MIDDLETON-ON-SEA PARISH COUNCIL

20th October 2019

Re: Planning Application M/80/19/PL–Former Poultry Farm Land West of Yapton Road – demolition of the existing structures and redevelopment to provide a new 66 bedroom care home (Use Class C2) arranged over two storeys together with associated access, car and cycle parking, structural landscaping and amenity space provision.

Key:

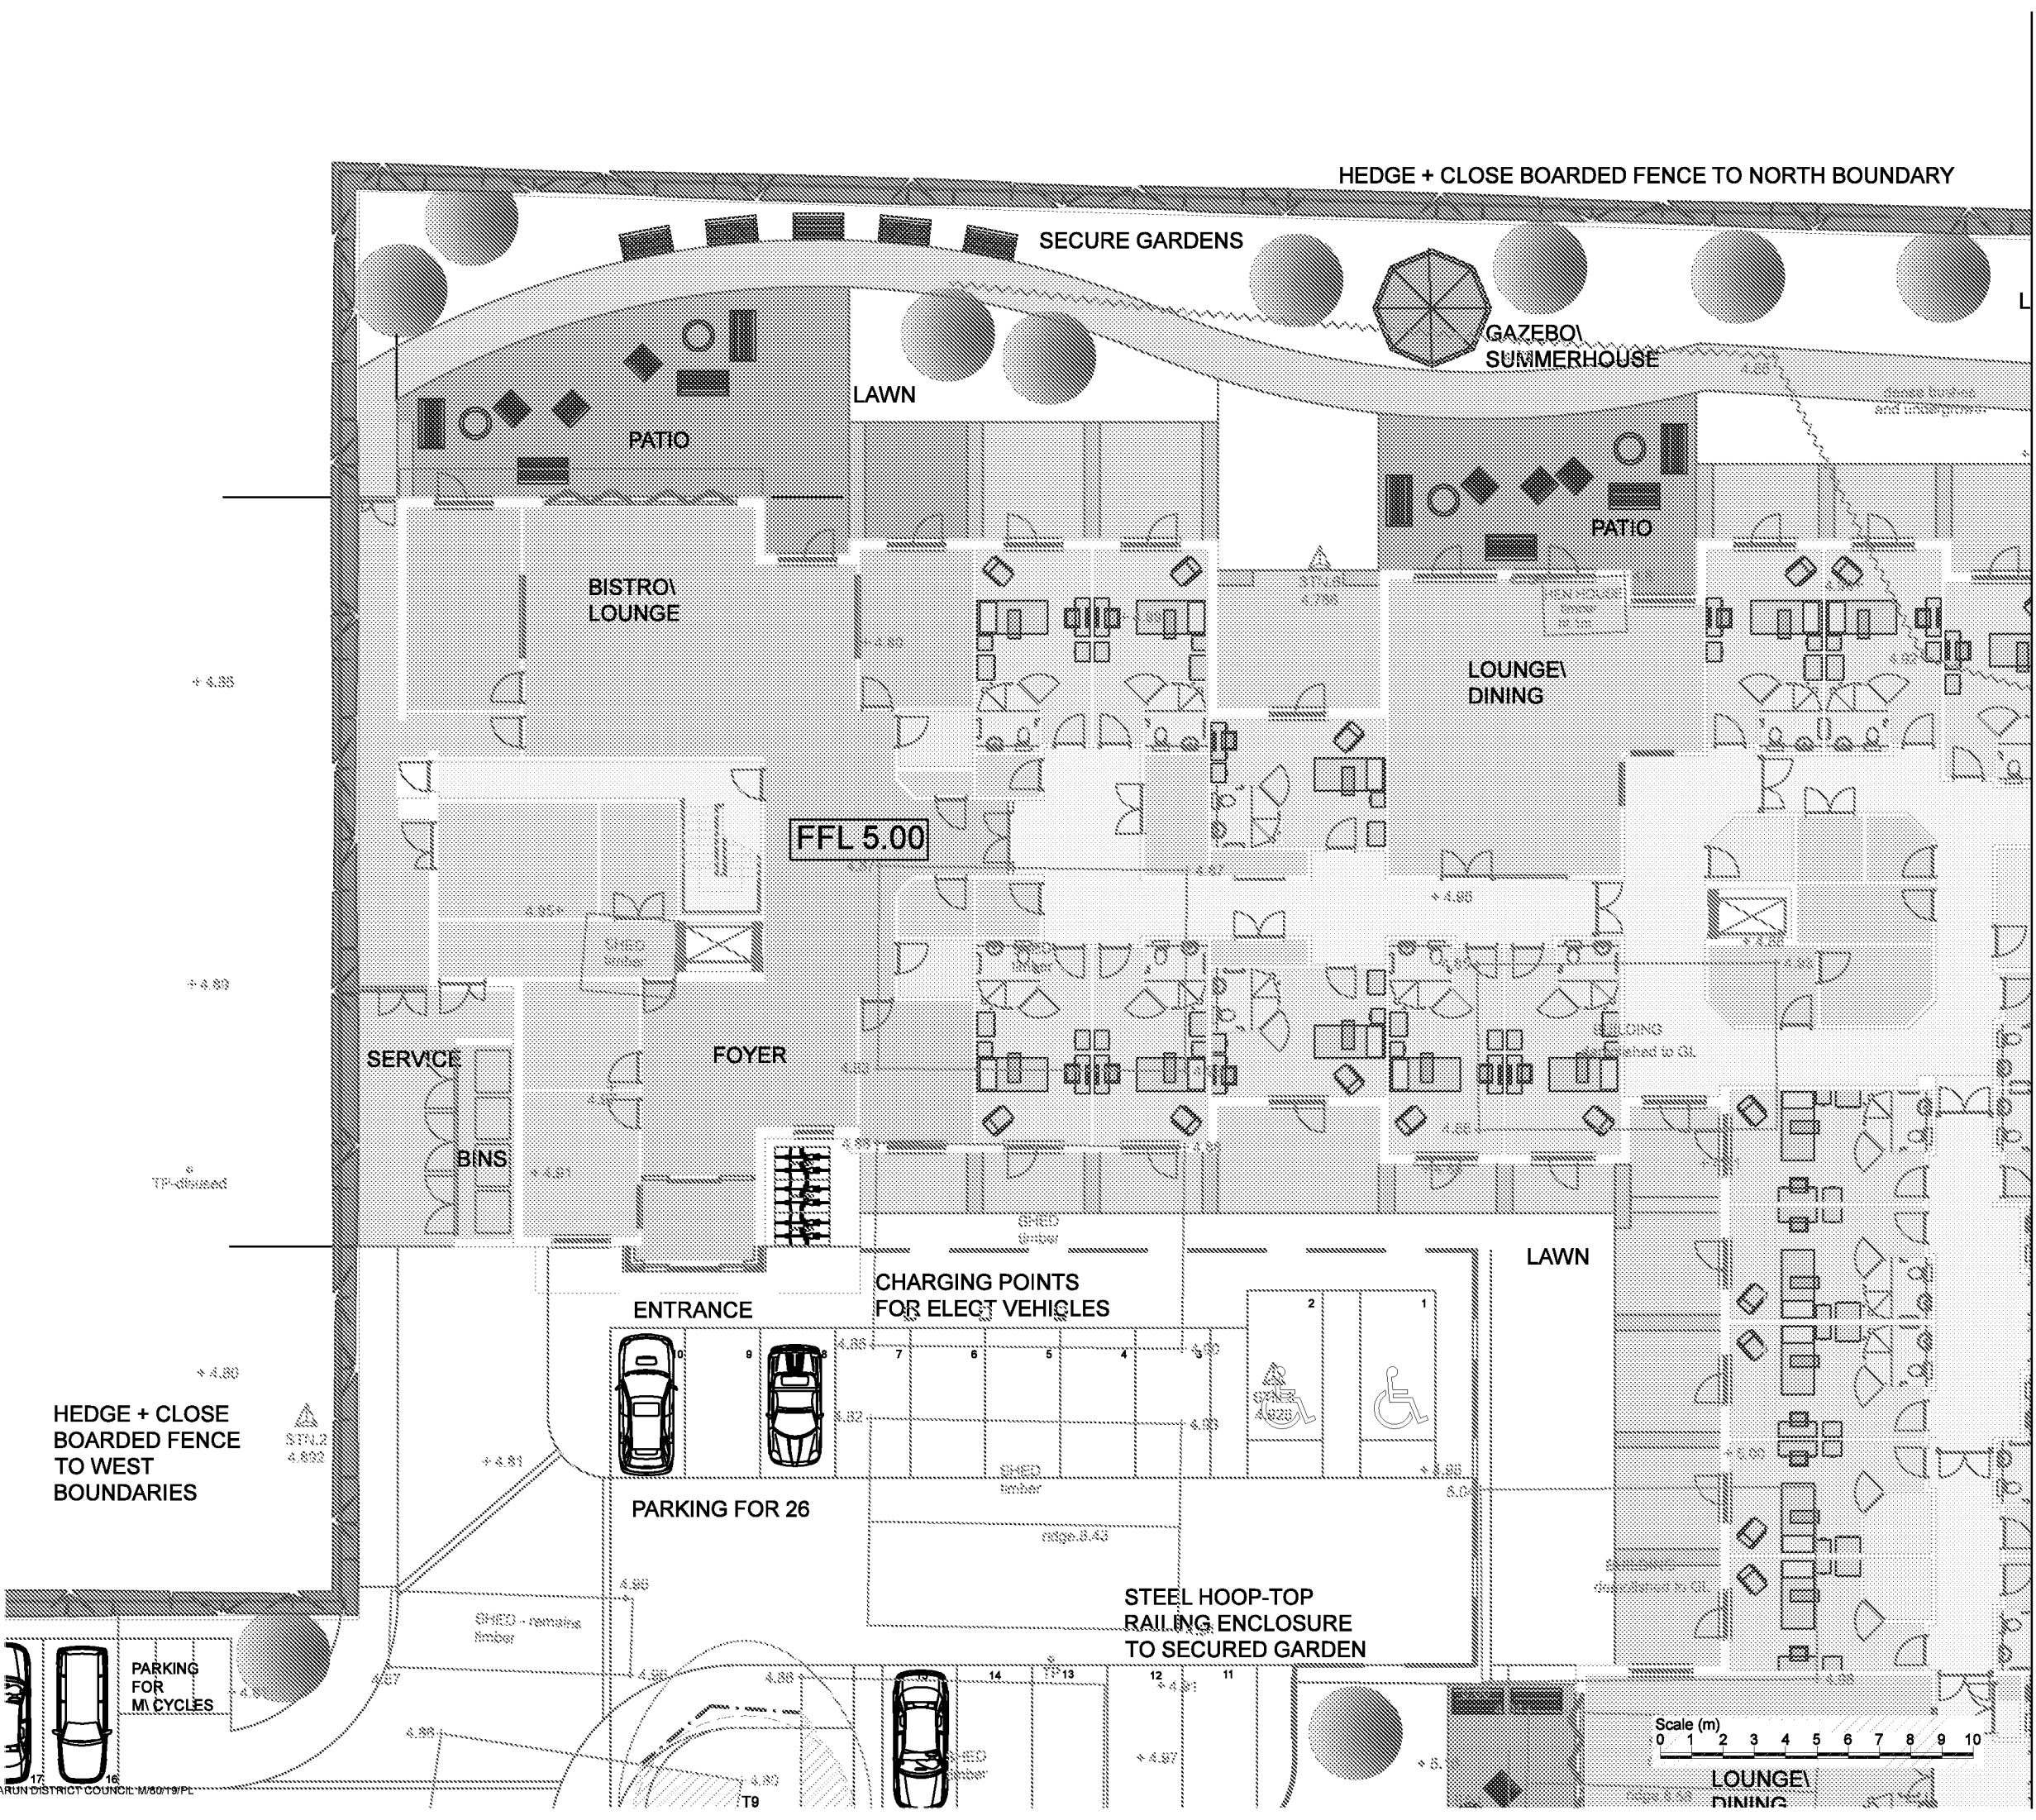
- **Loss of Trees & Trees with Tree Protecting Orders**
 - A number of trees are to be removed and there are trees on the site with protection orders which are close to the entrance of the site and these trees and especially their roots need to be protected by the building contractor. It is important that these TPO's are protected and although some evidence is shown within the reports on how this might happen we feel that more protection is needed. What are the consequences if the building contractor cuts down a TPO tree and how can we assess that the measures laid down in the report will protect the trees following construction if this planning application is approved.
